From: Mark Warwick
Sent: 08 March 2019 17:01
To: Claire Potts
Cc: Planning.Responses
Subject: AL/118/18/OUT

Planning Application Ref: AL/118/18/OUT

Location: Ryefields Farmhouse, Oak Tree Lane, Woodgate, PO20 3GU

Description of works: Outline application with some matters reserved for the demolition of existing buildings & the erection of 10 No. dwellings comprising 1 No. three bedroom detached, 2 No. three bedroom semi-detached, 4 No. four bedroom semi-detached & 3 No. four bedroom detached houses with associated access & parking

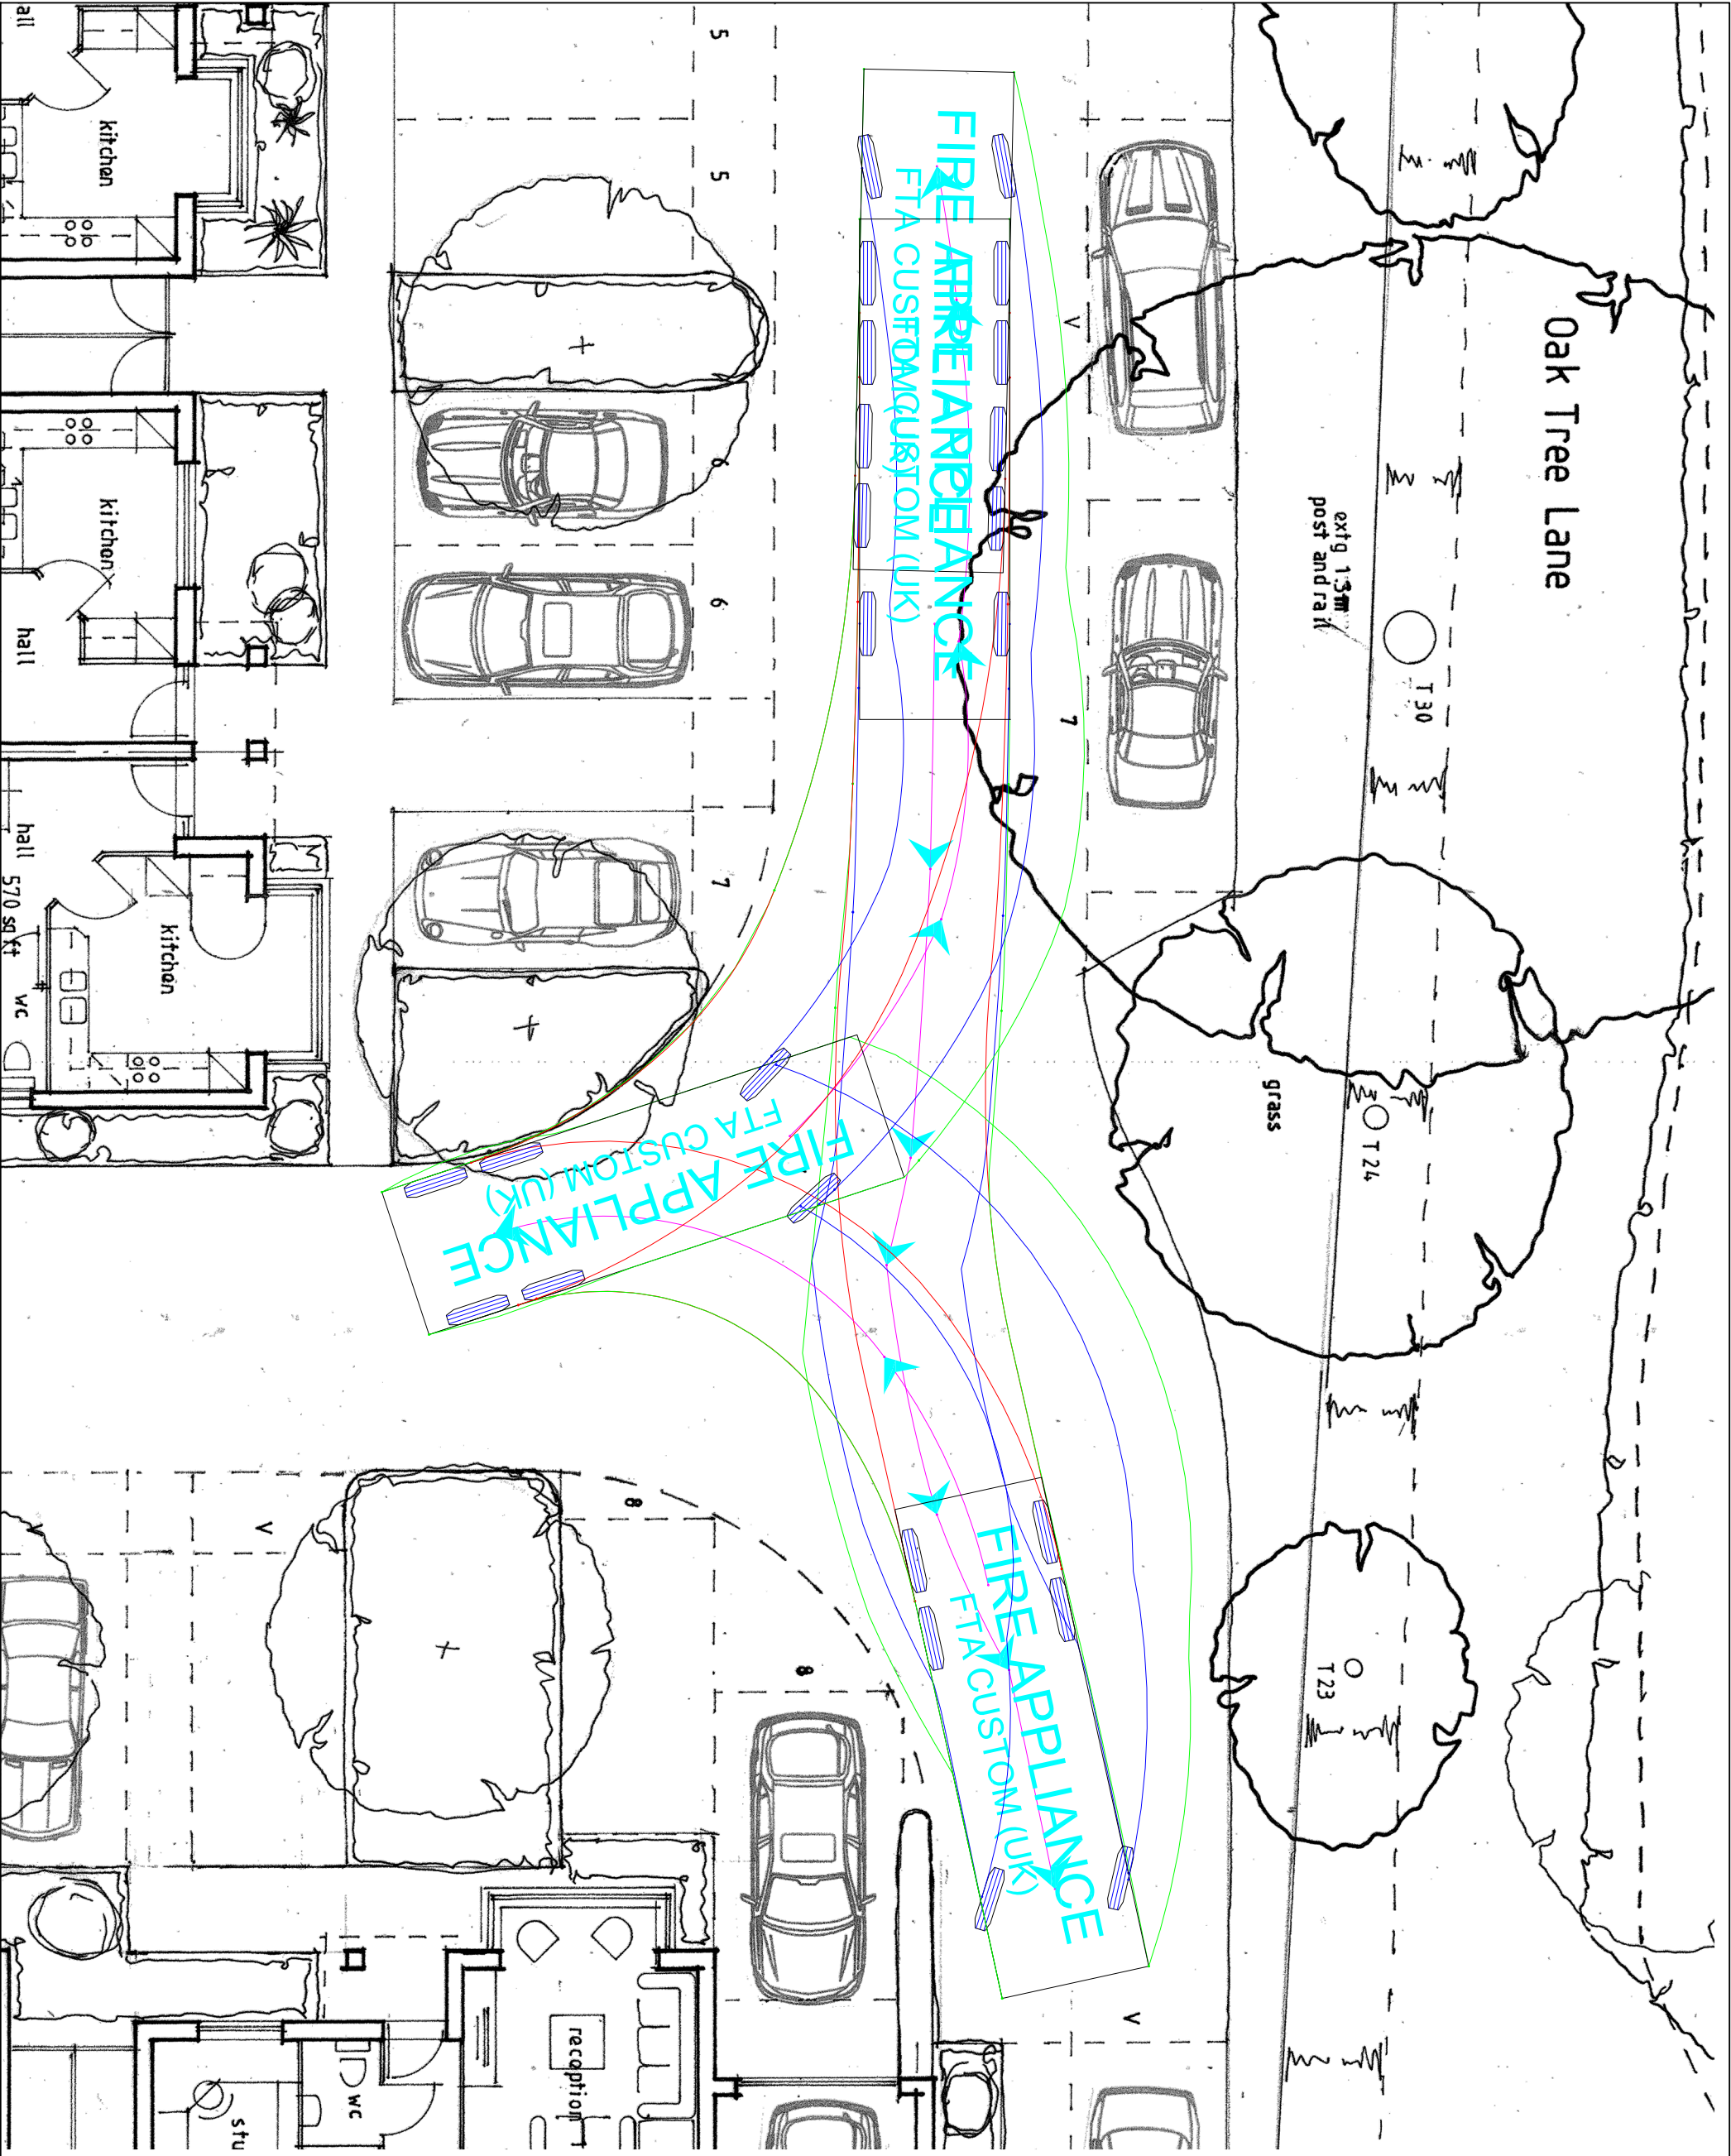
- The current proposed layout is going to impact on significant trees (T21 and T31) both above and below ground. Although achievable in principle by adopting the tree protection measures proposed; there is nonetheless a risk that attaches during such extensive incursion of root protection areas. This is especially significant where the trees in question are by far the most important locally.

- The proposed layout carries an avoidable risk of damage to significant trees of high landscape and public amenity value. An alternative layout that better respects those trees and which would not incur a substantial reduction of units seems achievable.
- I anticipate a revised layout being submitted that is more sympathetic to T21 and T31, to which I could lend my support.

- As it stands, I must register an **OBJECTION** to the current layout proposals.
- I recommend the making of a Tree Preservation Order in respect of T21 and T31 to preserve their place in the landscape and hopefully better inform a revised layout. I attach TEMPO forms and GIS plan for this purpose.
